Our Ref: 24096

31 January 2025

**RE: HOUSING AUSTRALIA FUTURE FUND – MAROUBRA – BH2NJ
RESPONSE TO SUBMISSIONS – TRAFFIC AND TRANSPORT**

DWG No. LSK-01

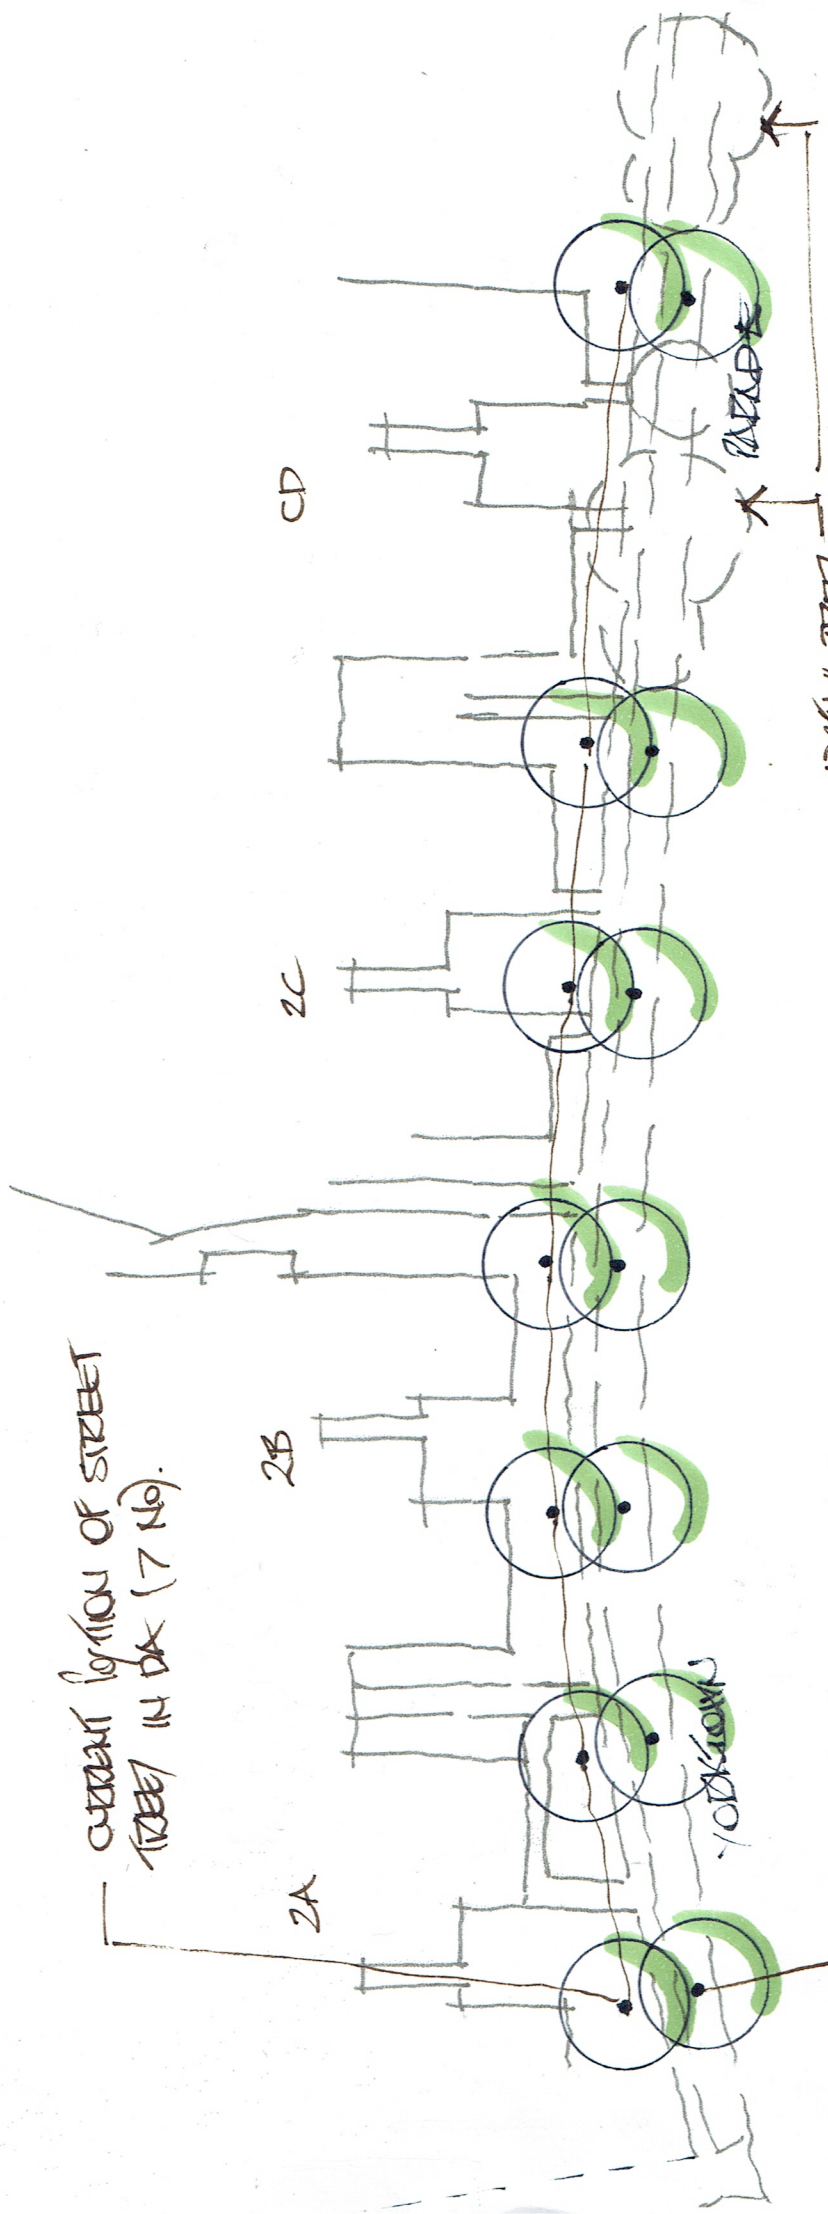
11. Submission comment: Concerned impact on adjoining development due to minimal setback of driveway to boundary. Requests extensive planting and screening within the site to minimise impact.

TPP response: Planting and screening along the western property boundary is not expected to impede sight distance from the driveway along Fitzgerald Avenue. Refer to the sight distance triangle in Appendix B of the Transport and Accessibility Impact Assessment.

Further, a 2m x 2.5m pedestrian sight triangle will be provided at the driveway exit in accordance with AS2890.1 -2004 Parking facilities – Off-street Car Parking to ensure planting and screening would not impede the sight distance to pedestrians.
